**Alterations and additions to Kincoppal-Rose Bay School (SSD-10325)
Response to Submissions**

ATTACHMENT 1

AR-ABC-A1-01

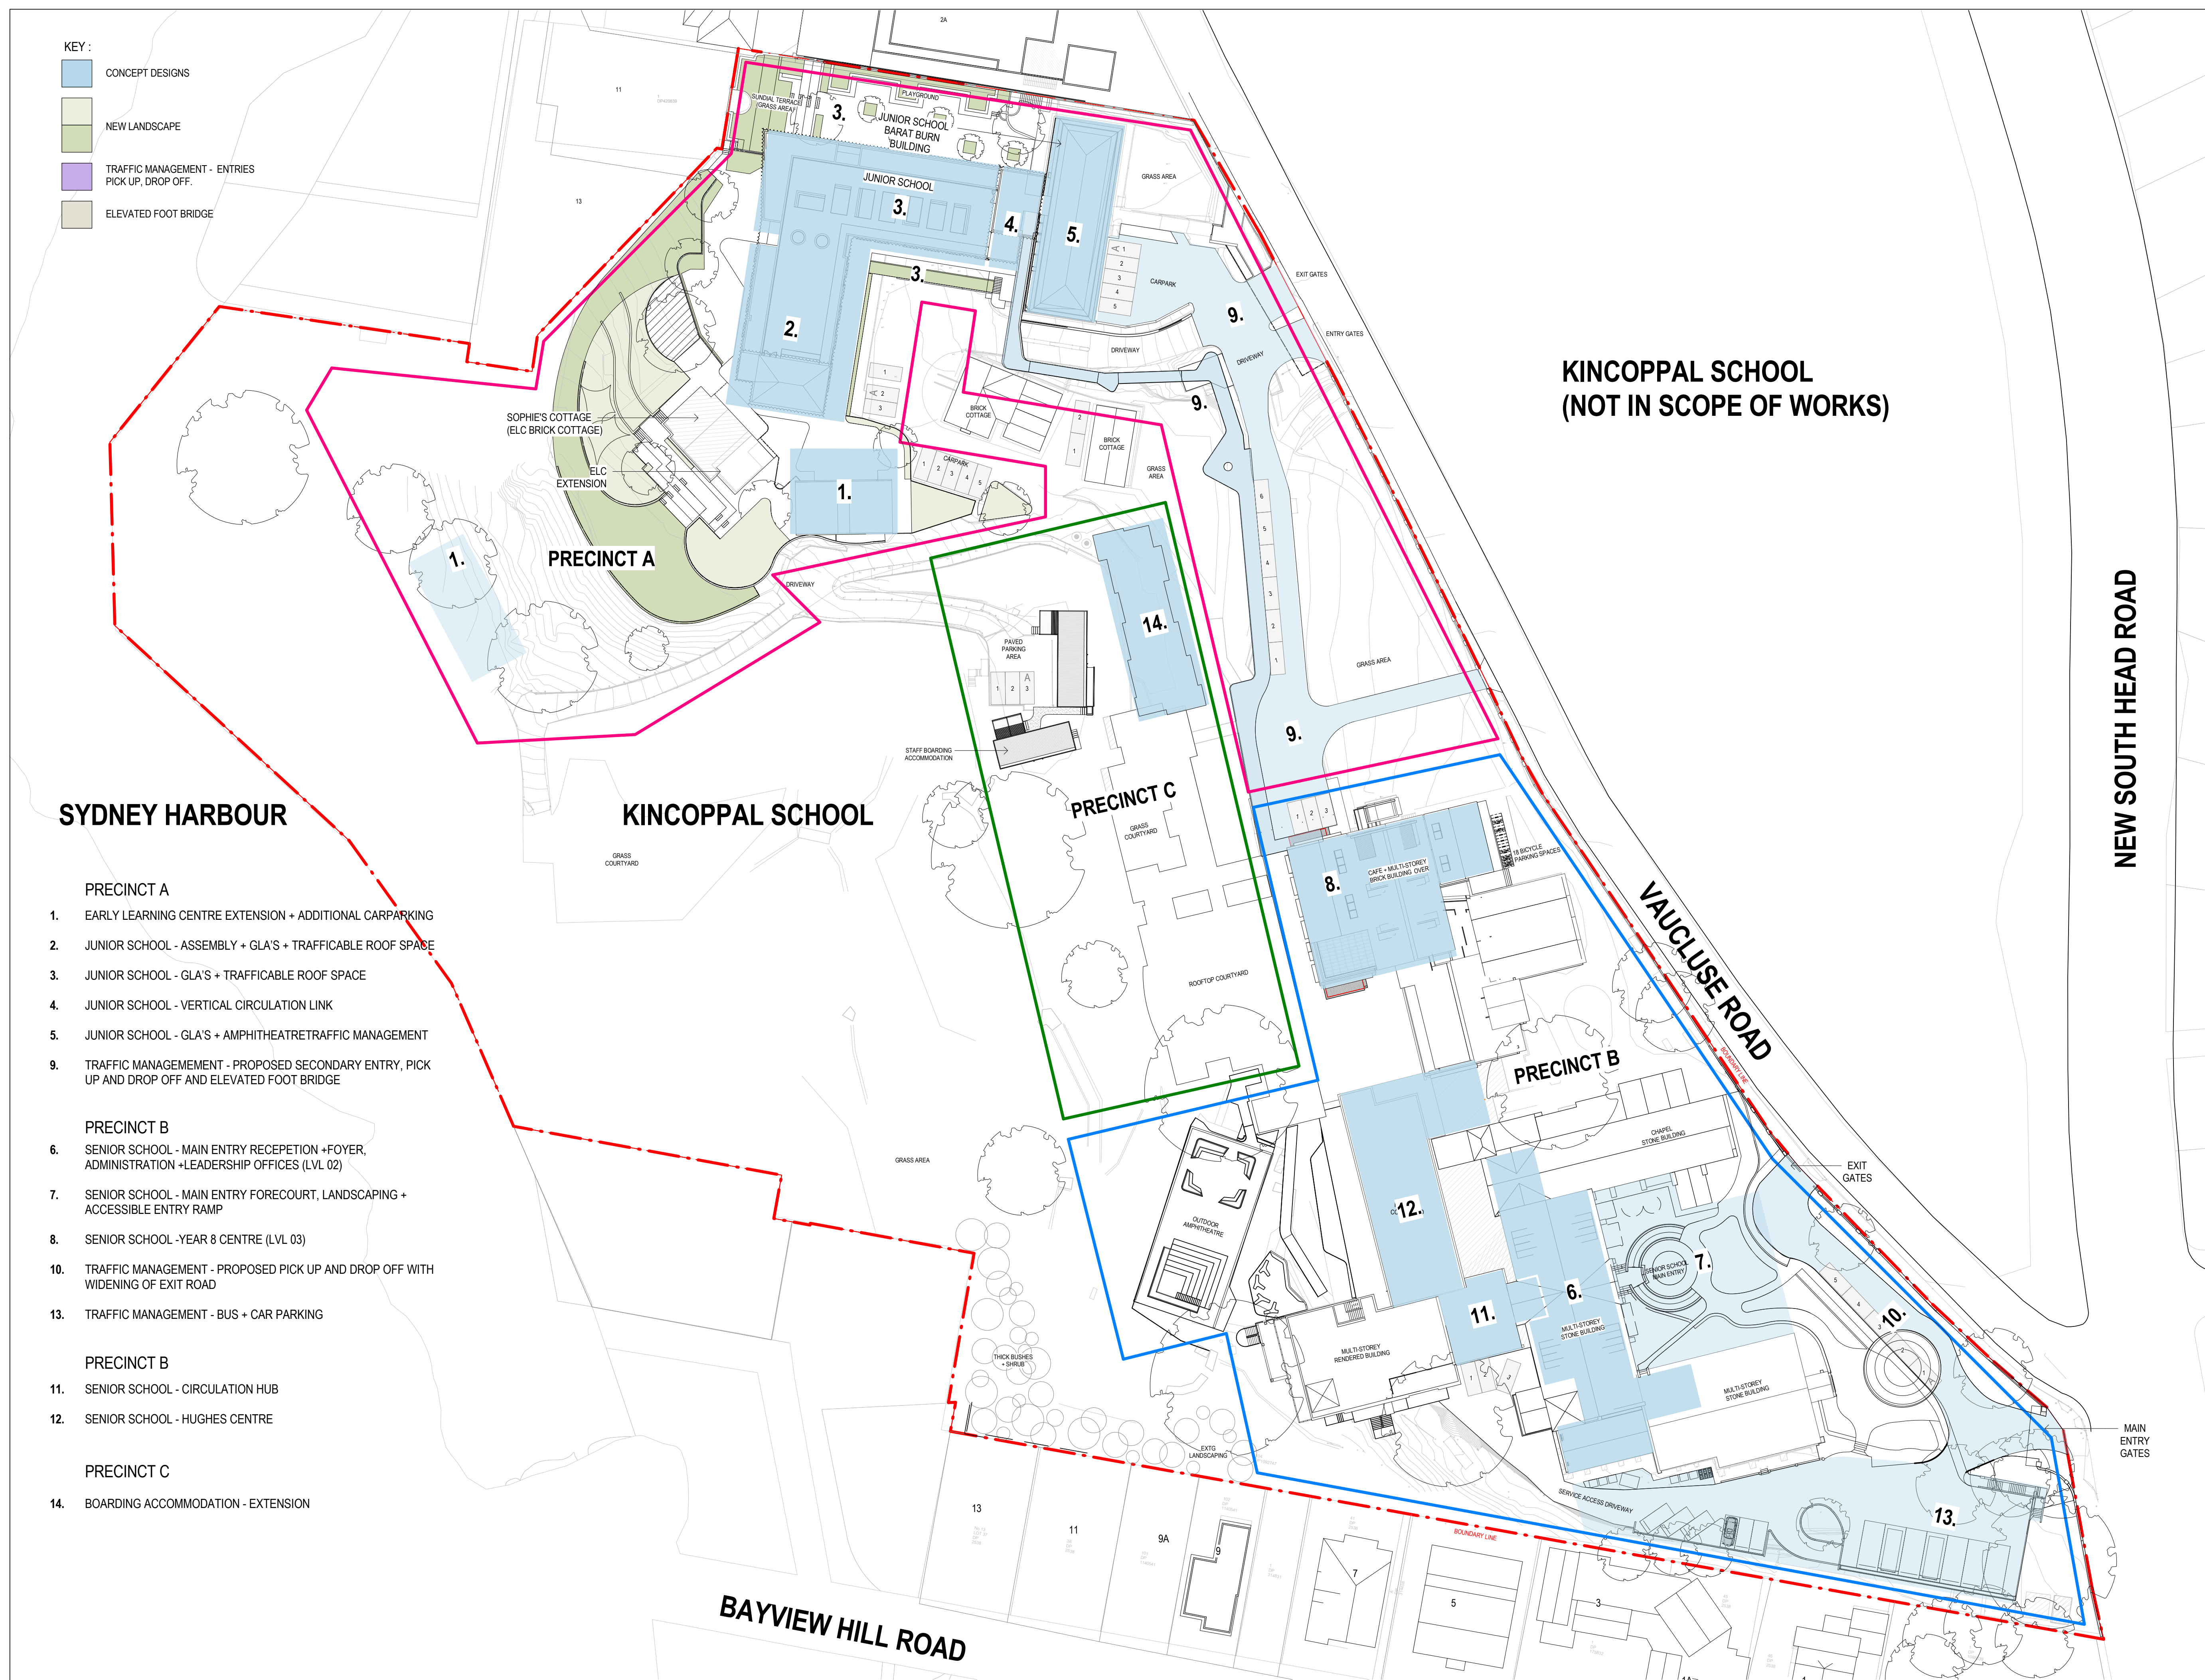
- The development includes additional parking in Precinct A; however, there are inconsistencies between documentation. For example, on the proposed site plan (AR-ABC-A1-01 revision 4) there are three parking spaces proposed behind the ELC's outdoor play area; however, these spaces are not shown in detail in the plan set for Precinct A (i.e. A-A0-00 – A-Y1-03). Additional information is required that clearly shows the location, dimensions and relevant details of all parking spaces proposed within Precinct A.
